**Consultation Response from Alan Smith,
KC Waste Strategy (Refuse & Recycling)**

2025/93385 The Bridge, 42, Market Street, Milnsbridge, Huddersfield, HD3 4HY

**Prior notification for change of use from commercial/business/service to one dwelling (within a
Conservation Area)**

Responding Ref: WPS 25 075

Proposed Block Plan
Change of Use of Cafe to Dwelling

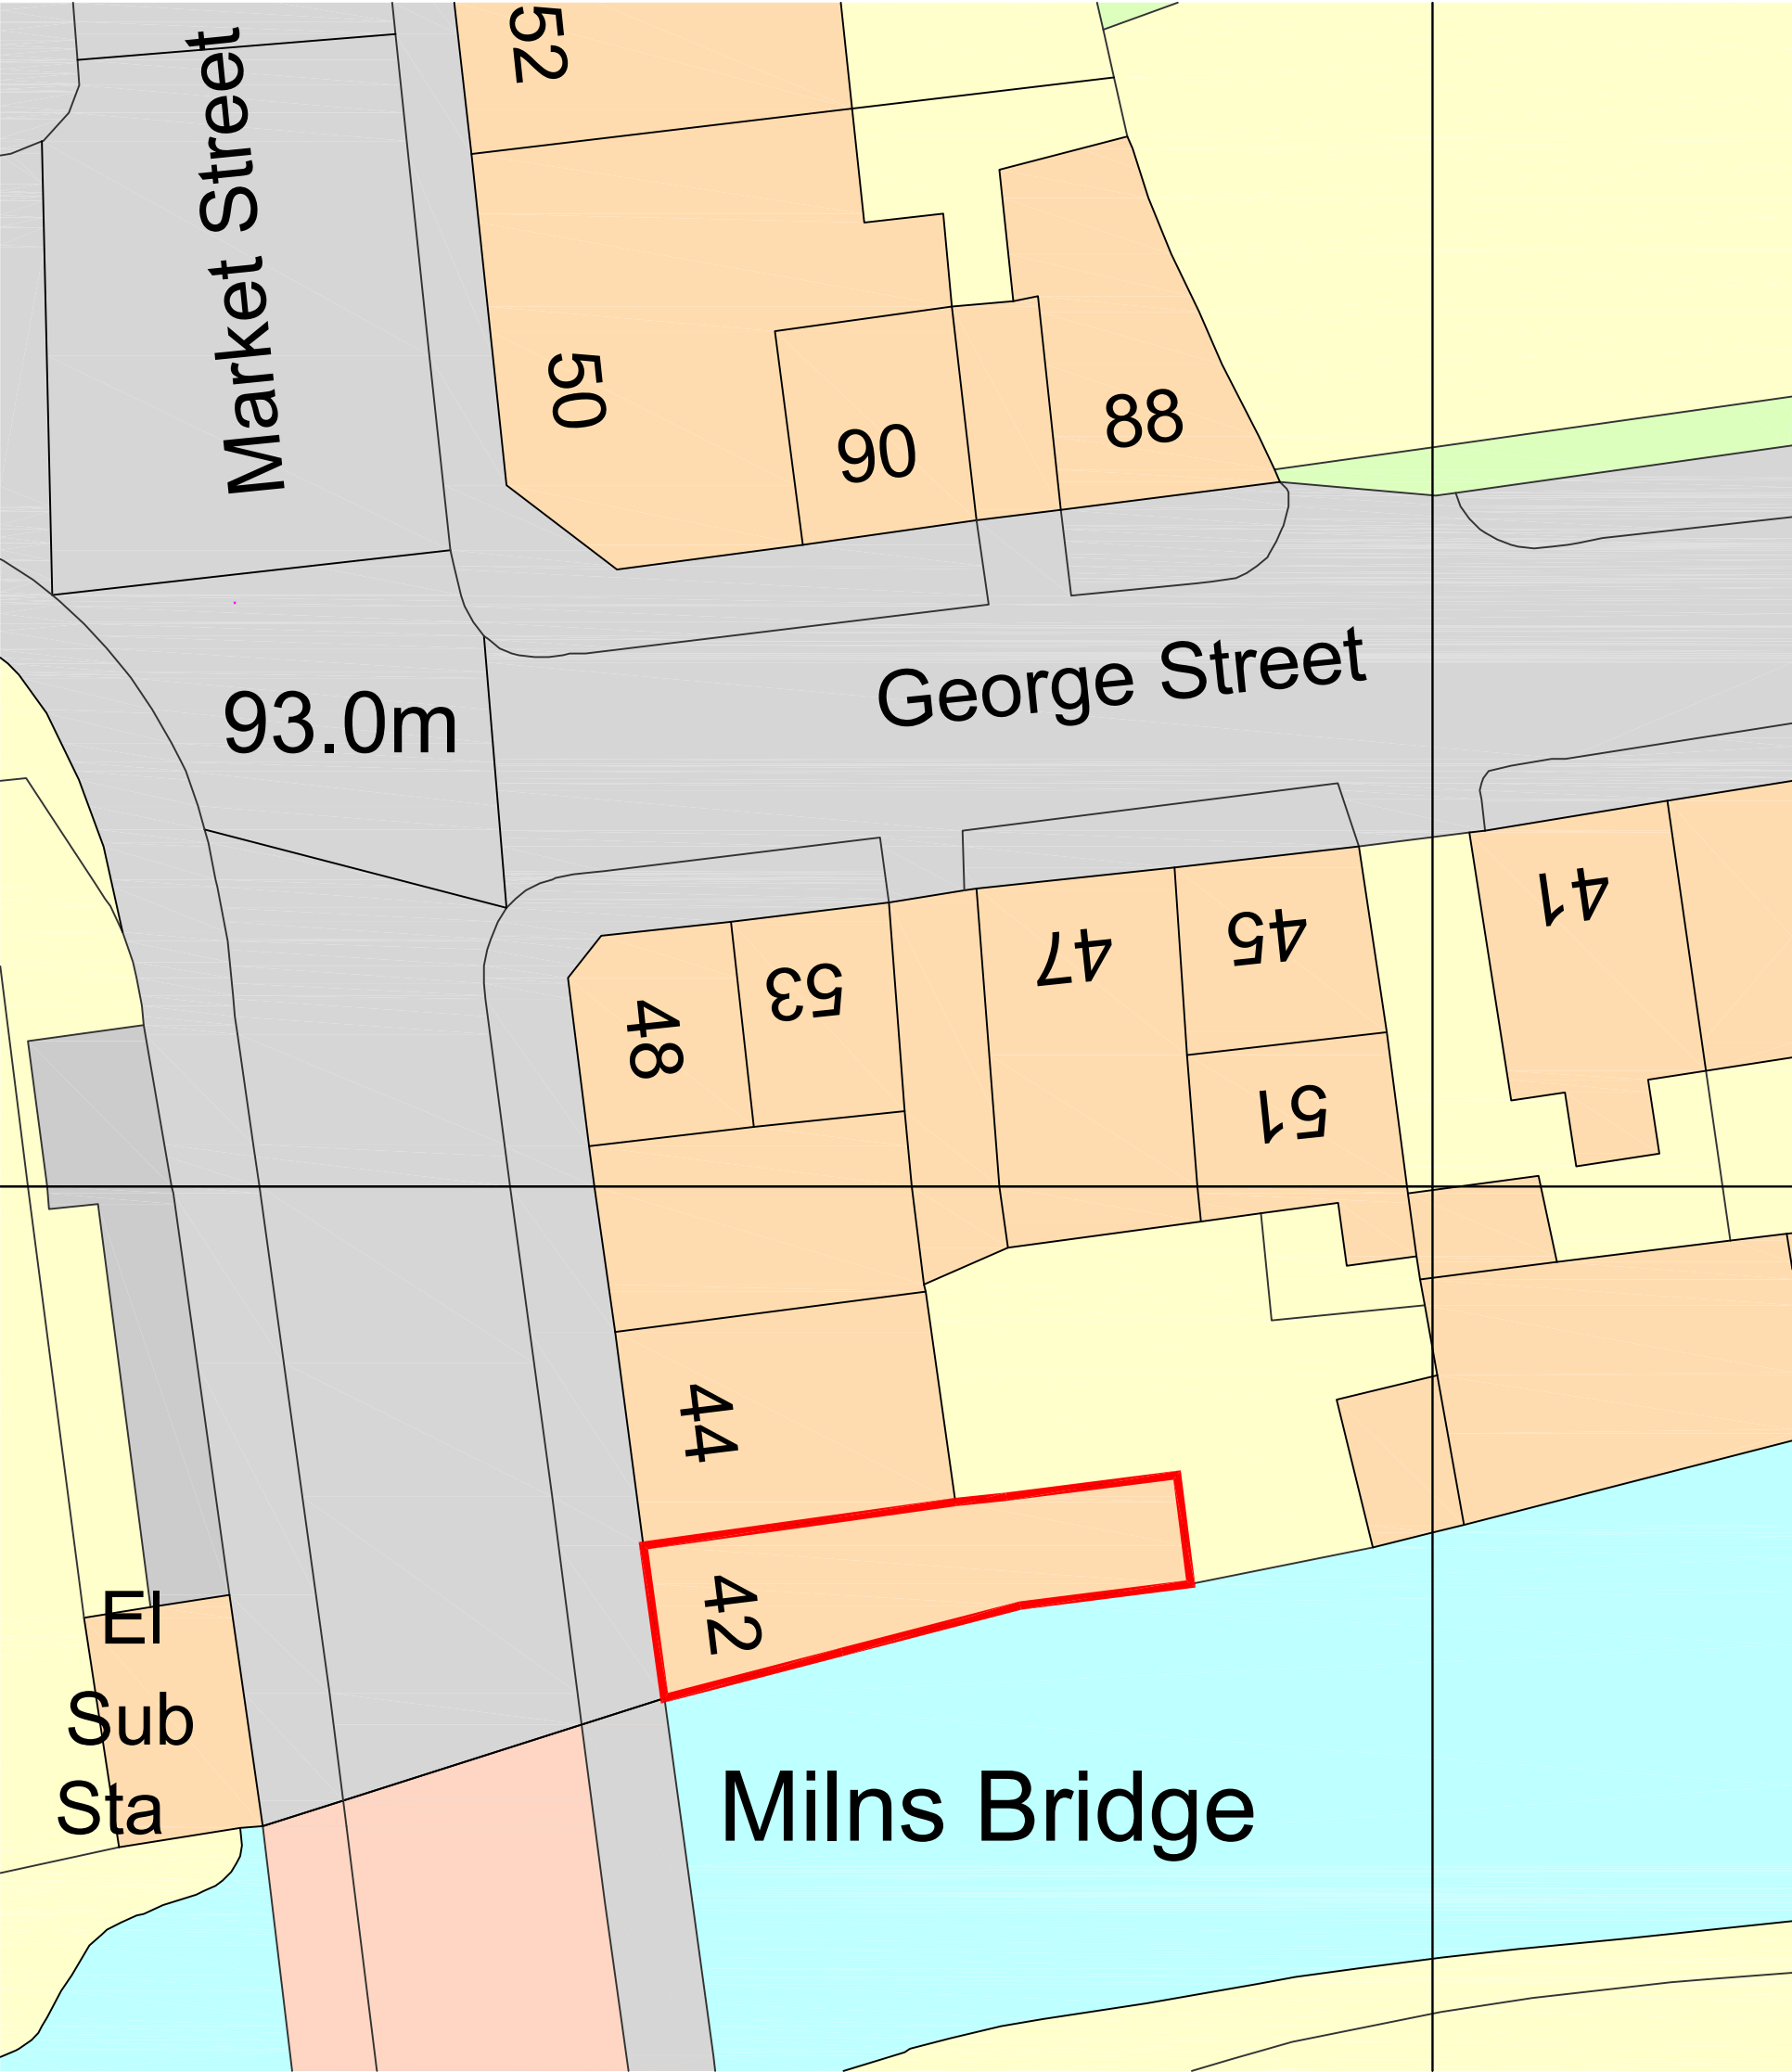
- **3 x 240L wheeled bins for:**
 - Residual waste – collected on alternative weeks
 - Recyclable waste – collected on alternative weeks
 - For future Simpler Recycling legislation provision
- **Bin space dimensions:**
 - floor space required is 940 mm x 780 mm per bin
- **Bin storage location:**
 - Must not obstruct highways or driveways
 - No gradients steeper than 1:12 or steps
 - At least 2.5 m away from the nearest building to avoid fire risk

- Must be shown on a layout plan for the property, adjacent to the nearest highway
- No gradients steeper than 1:12 or steps from storage area to BCP
- Located adjacent to an adoptable highway
- Solid surface required, resistant to constant wear and tear
- The maximum drag out distance from bin storage area to BCP is 25 m (BS5906:2005)

Prior to commencement the developer must submit for approval details for bin storage, screening and BCP. The approved details shall be provided before first occupation and shall be so retained thereafter.
